Subject: Forest Heights Minor Subdivision (MS-206)

The Community Services Department has reviewed the Forest Heights Minor Subdivision. The following review was presented to the Park Advisory Board and the recommended motion was endorsed on January 13, 2021:

FOREST HEIGHTS ESTATES FINAL PLAT.

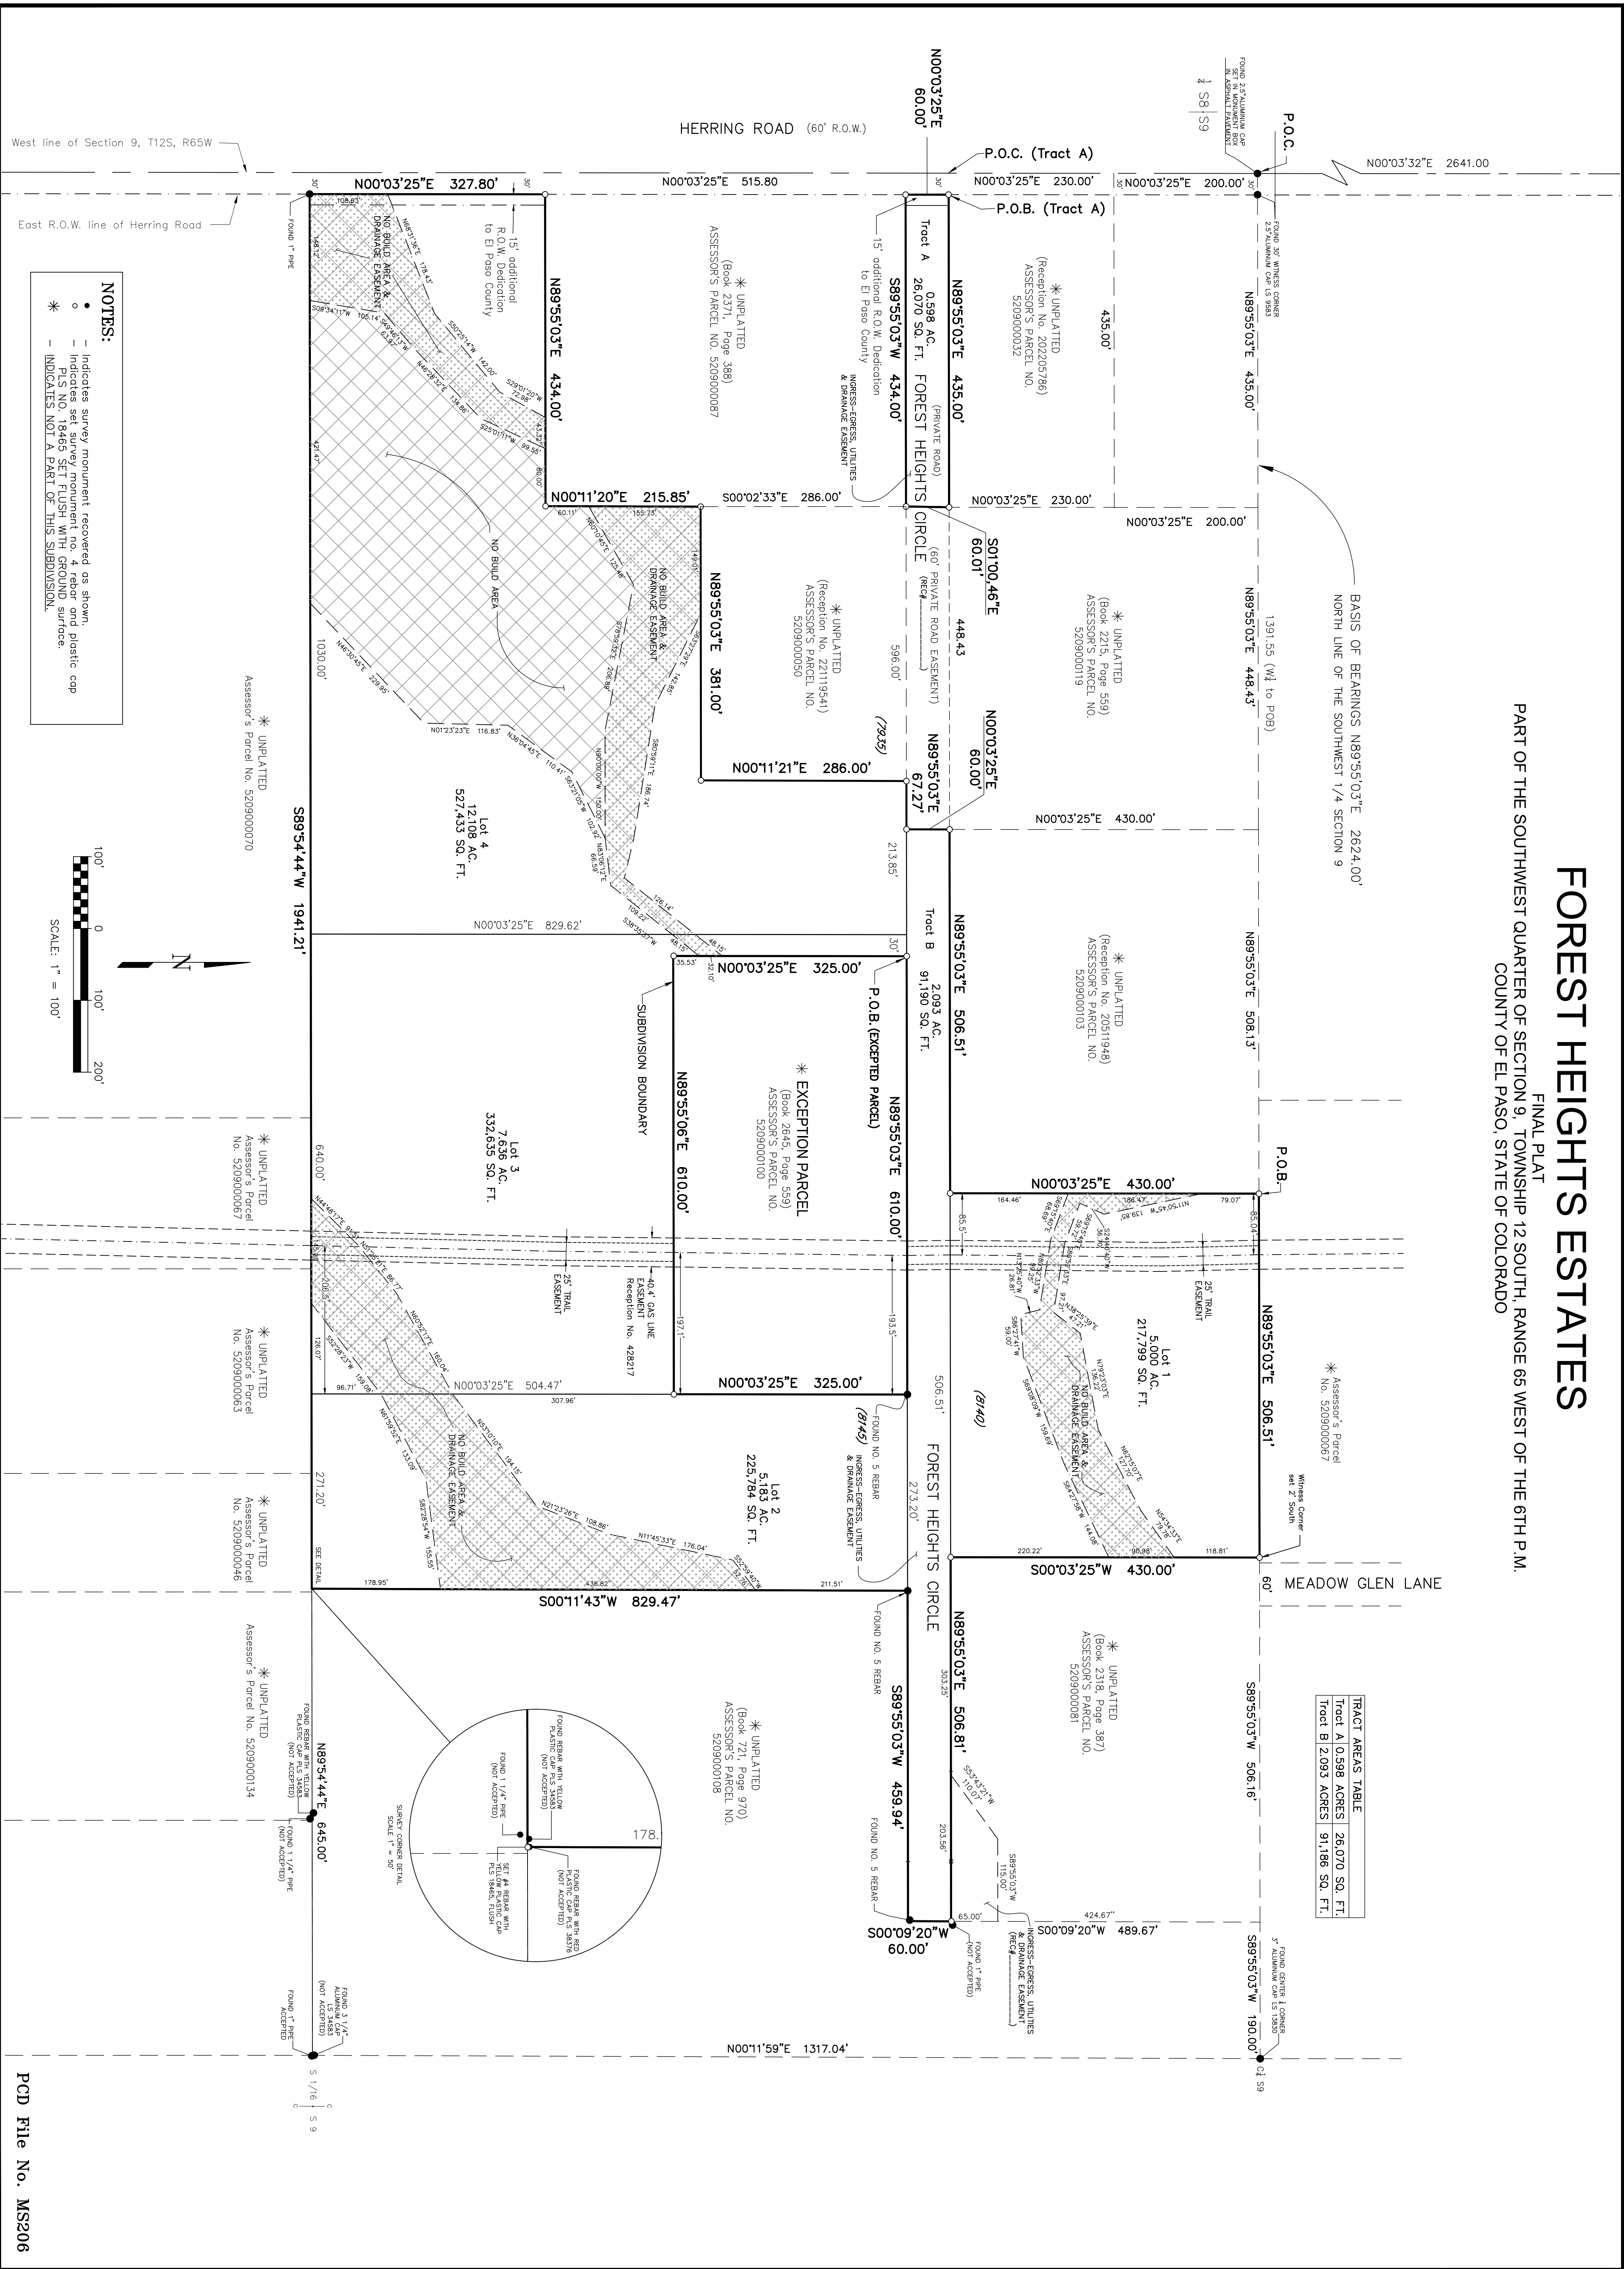
County Parks requests trail easements where development projects impact proposed to County trails. As it pertains to this application, the County requests that the landowner provide a 25-foot public trail easement shown in the existing gas pipeline easement that allows for the construction and maintenance

by El Paso County of a secondary regional trail, and this easement shall be shown and dedicated to El Paso County on the Final Plat.

In light of a recent discovery, Parks staff have identified a proposed Black Forest Trails Association (BFTA) equestrian trail impacted by this project. Parks staff recommends the applicant reach out to BFTA to discuss conveyance of a trail easement.
